**Consultation Response from KC,
Lead Local Flood Authority**

2021/91506 Shop Lane, Kirkheaton, Huddersfield, HD5 0DB

Reserved matters application pursuant to outline permission 2014/92535 for erection of 48 dwellings, formation of access and associated infrastructure

Date Responded: 7th November 2022

Drng. No. **0906/09/SK5** Rev **C**

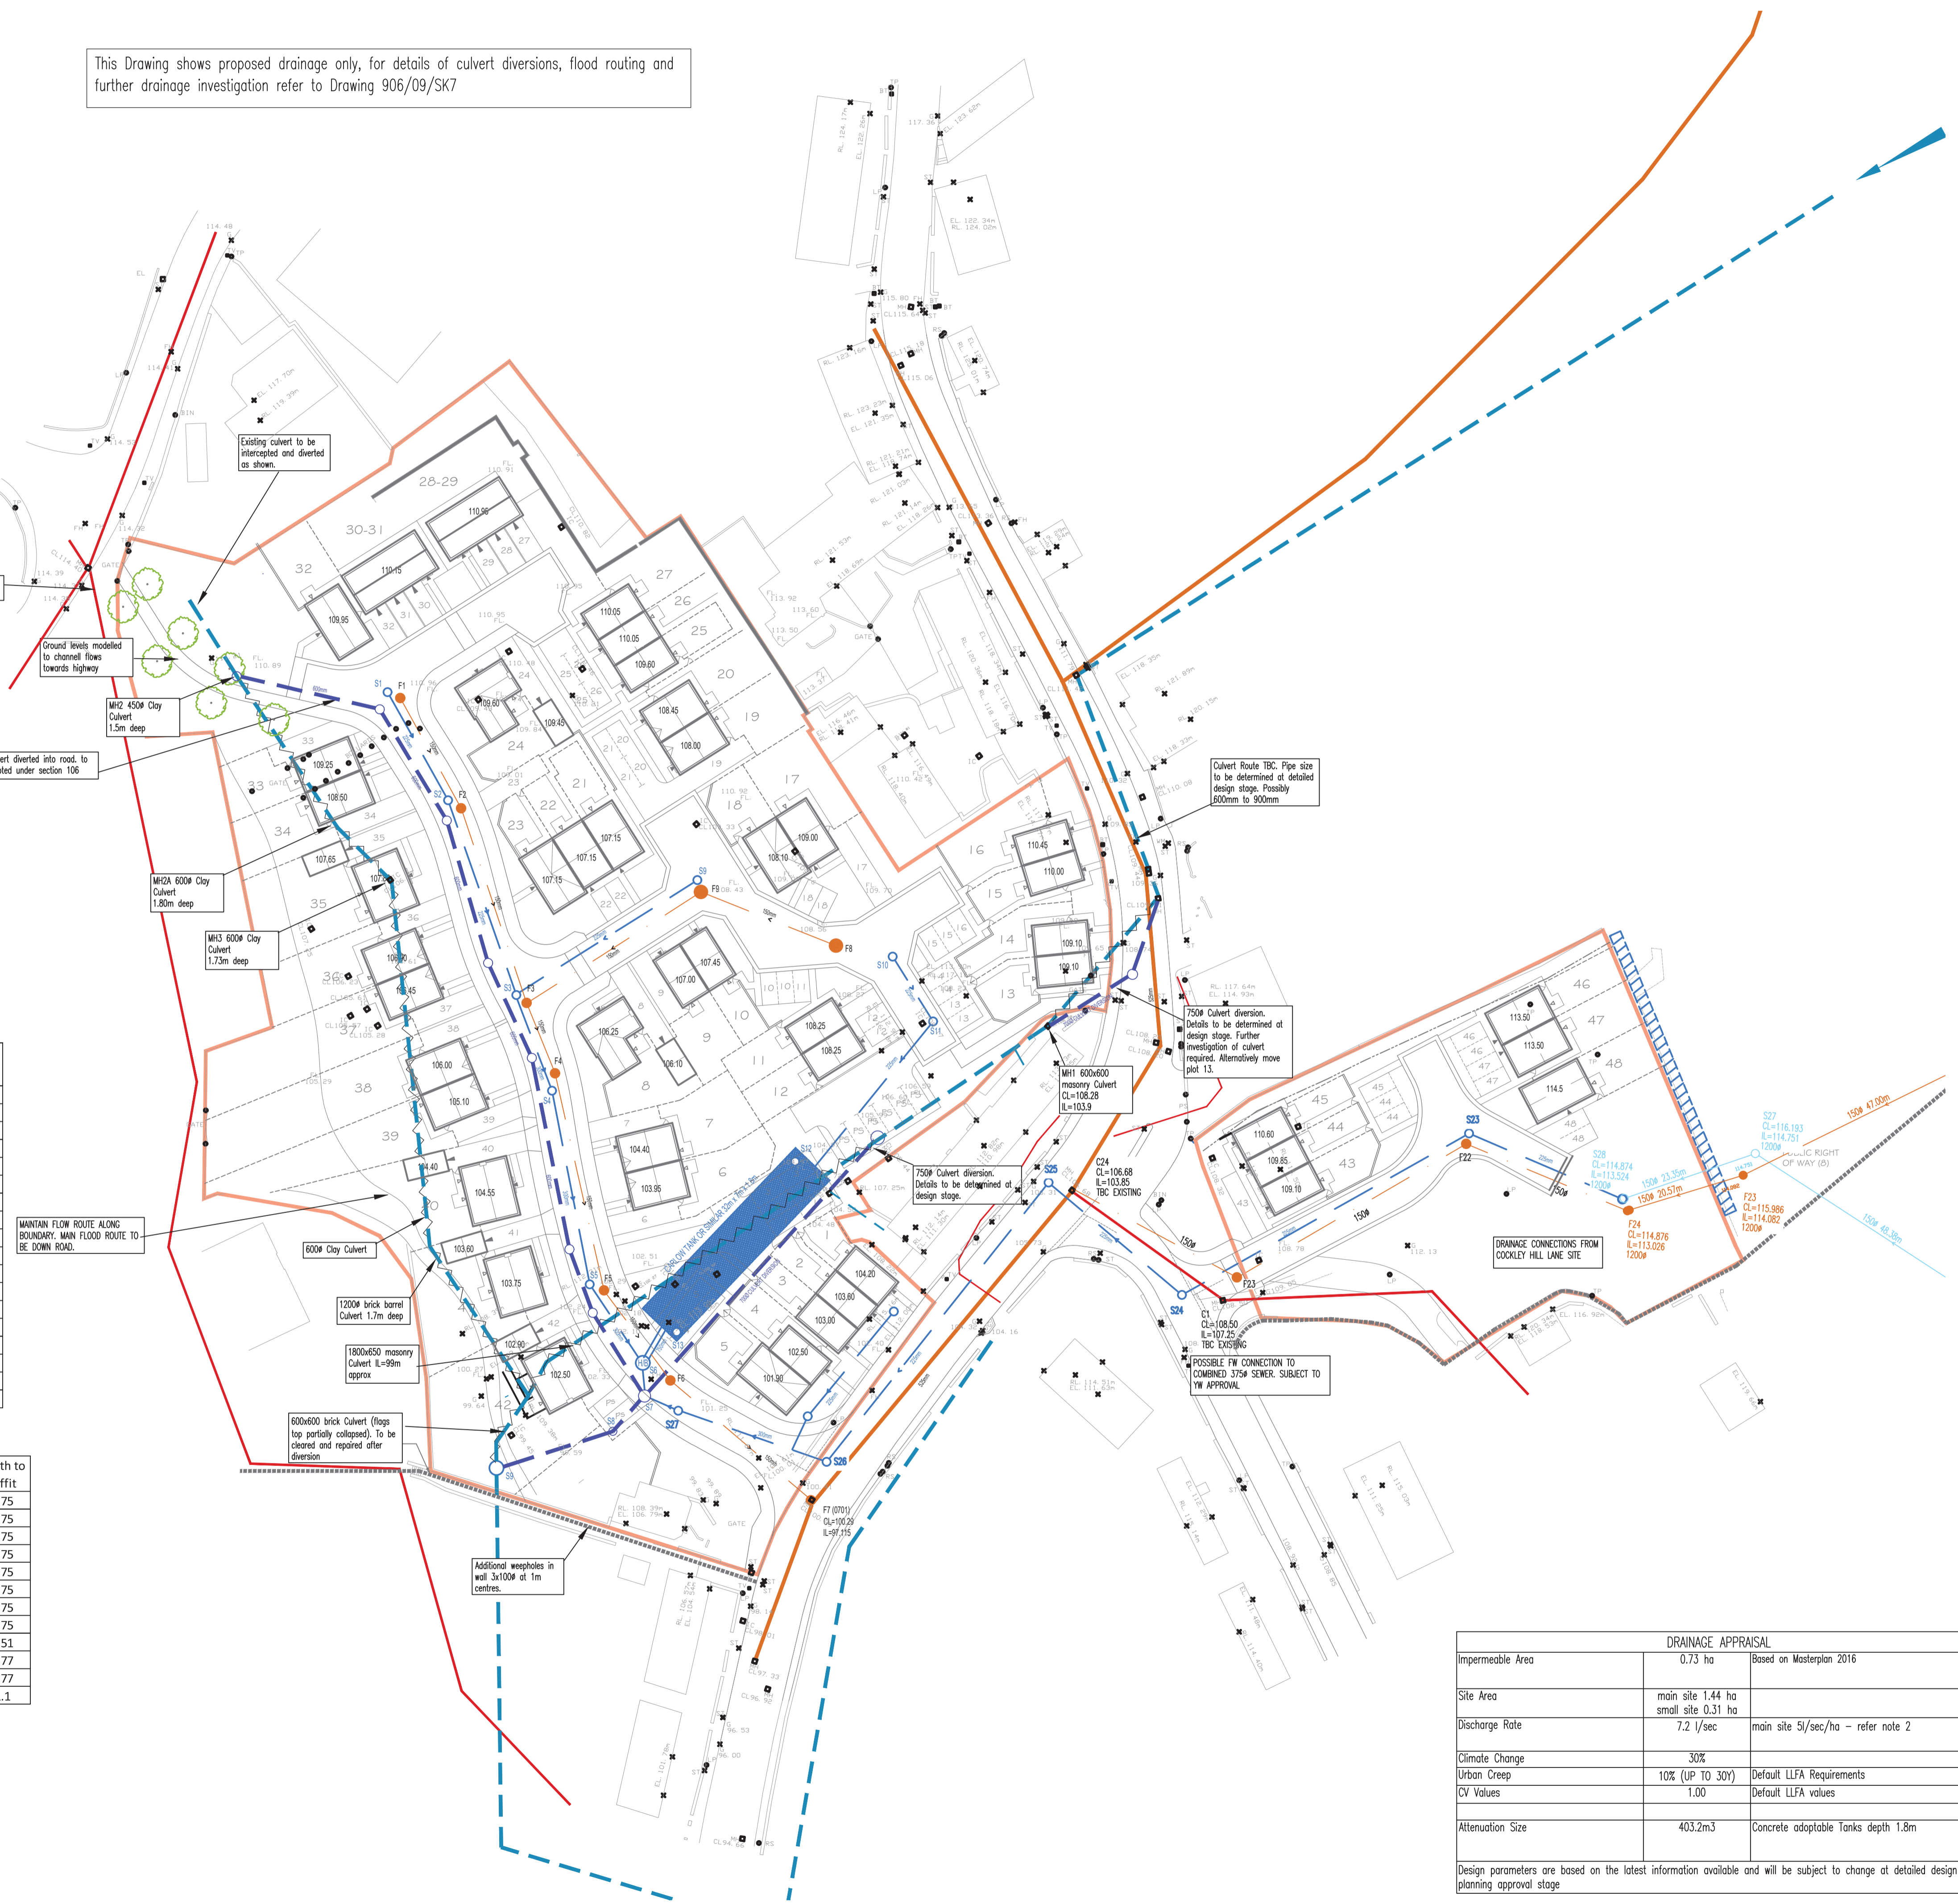
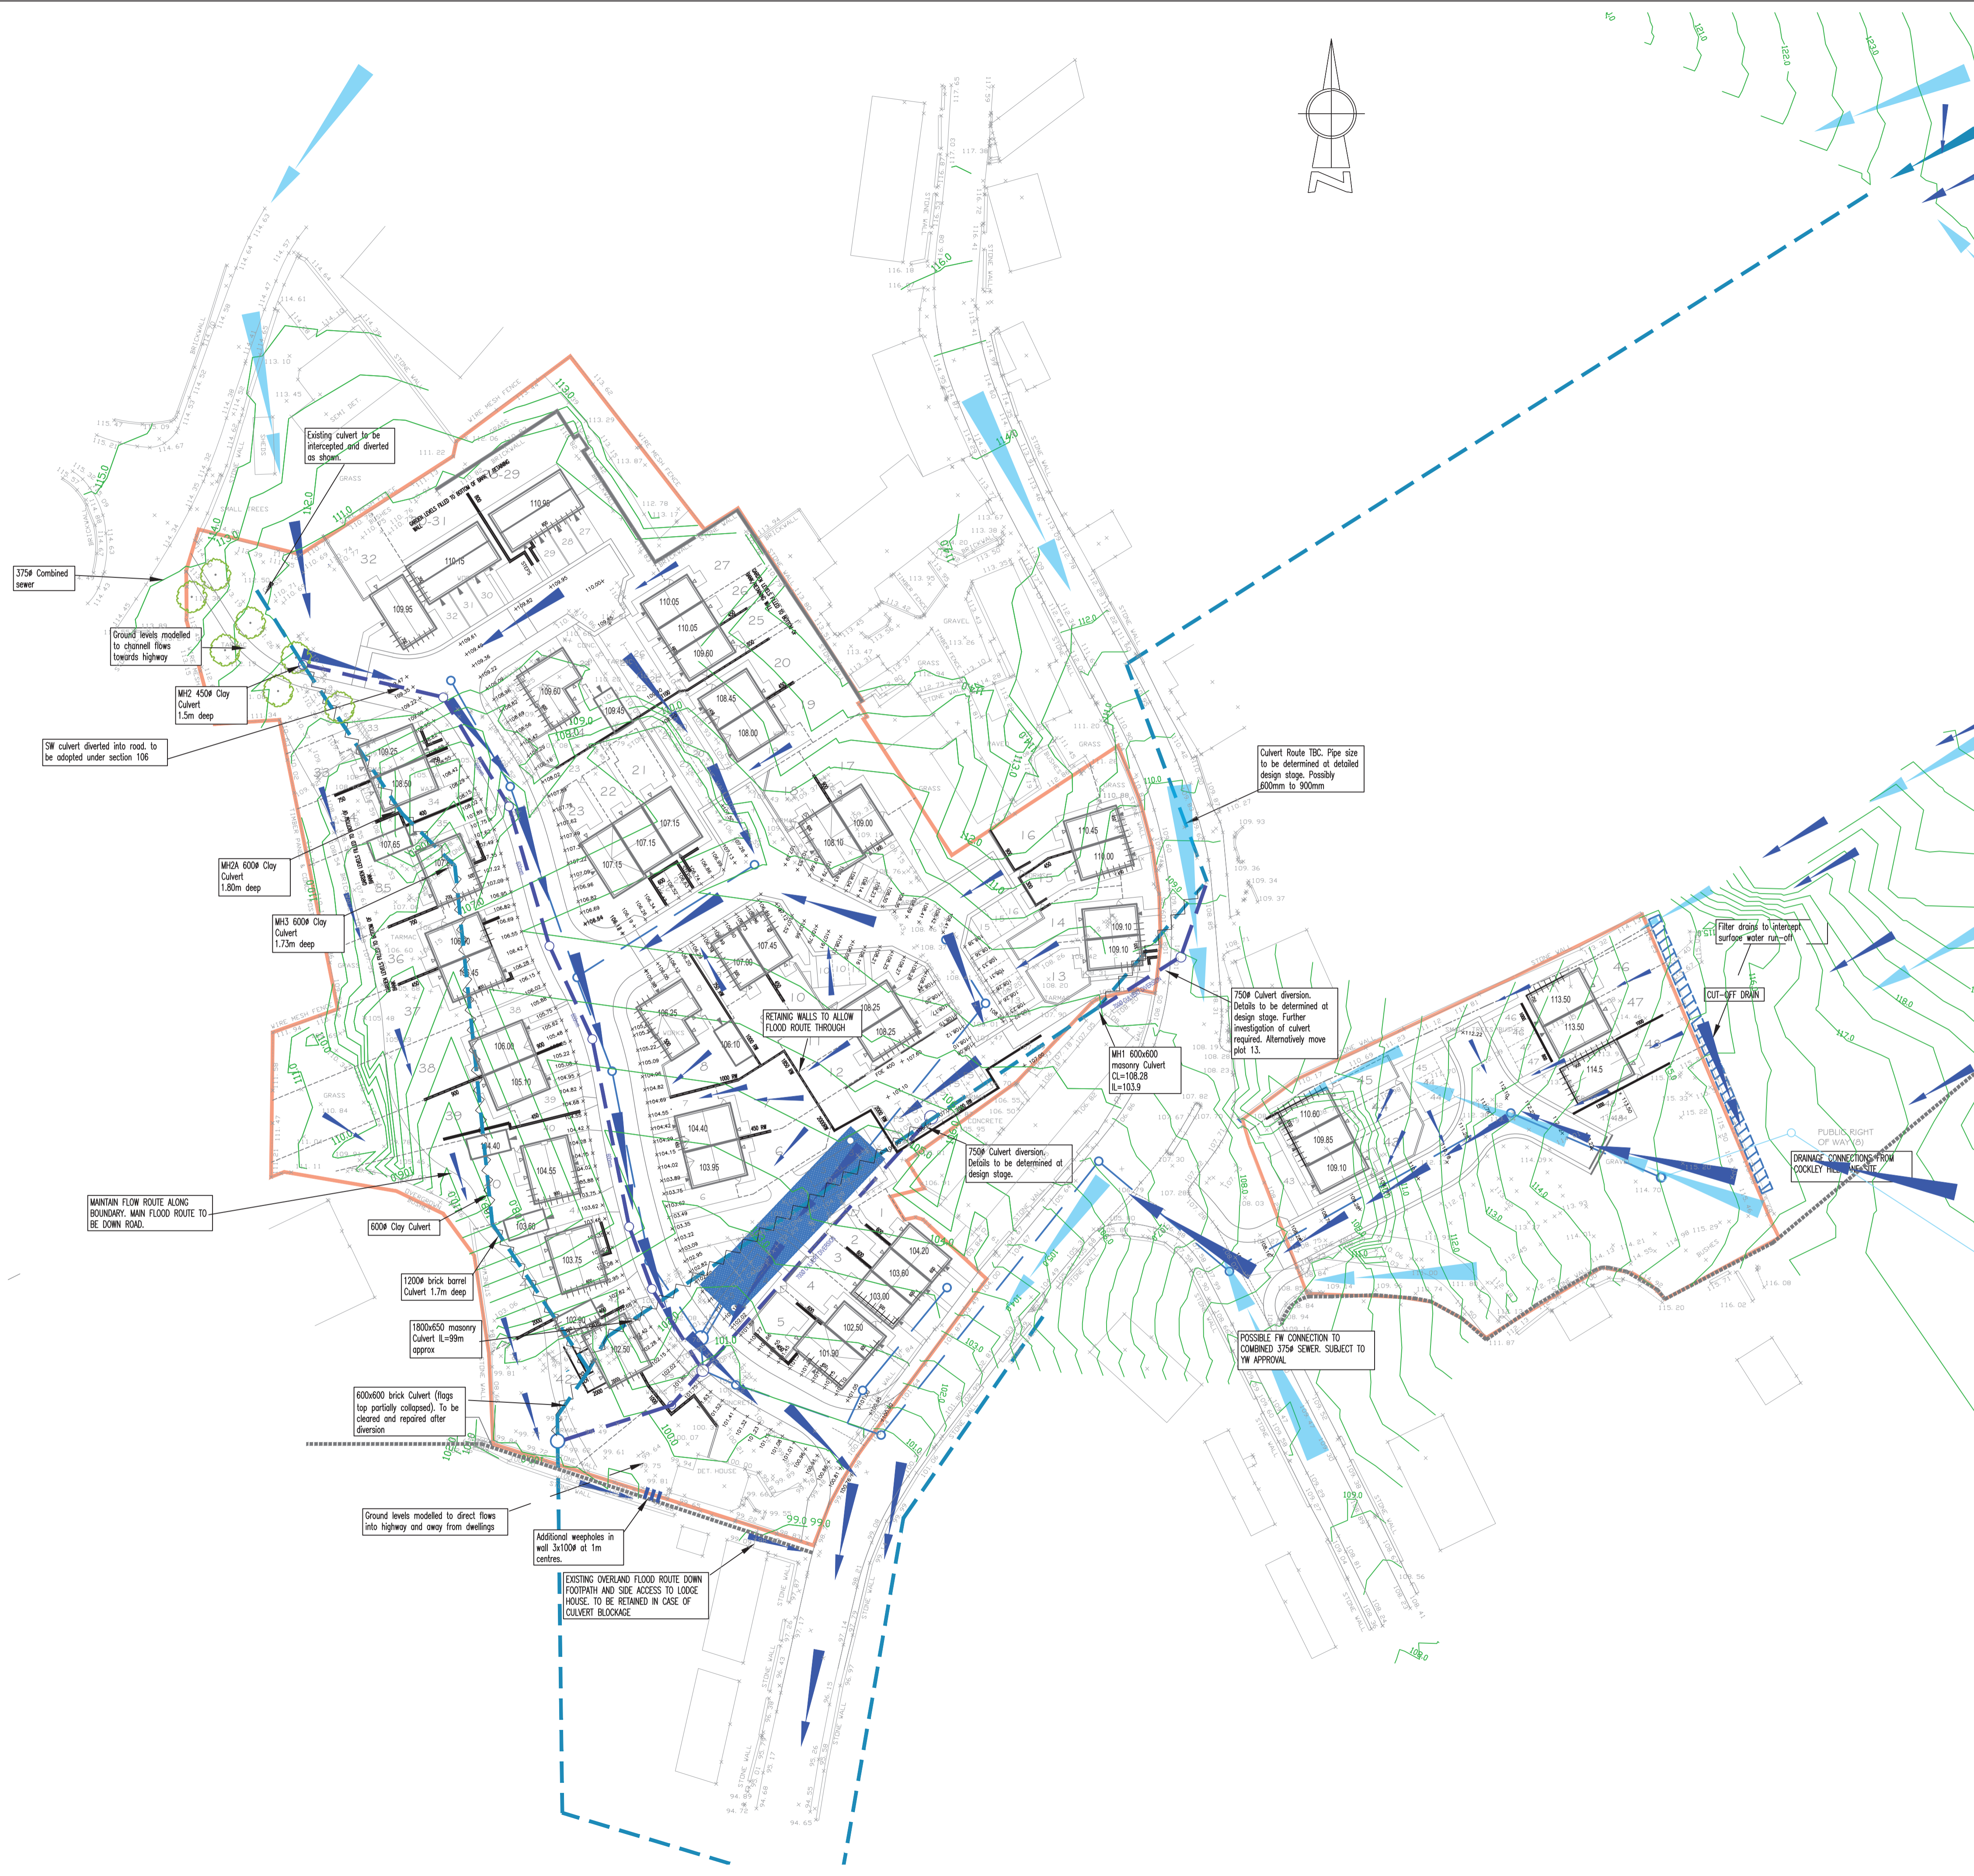
A discharge rate of 7.2l/s is shown on notes on drainage layout. After a re-examination of our pre-application advice and the presence of the existing mill pond despite demolition of the mill over a decade ago, I can allow an increase of surface water discharge rate of 11l/s. We also do not demand a 10% allowance for urban creep as the 1 in 100-year critical event with a 30% allowance for climate change will be stored underground.
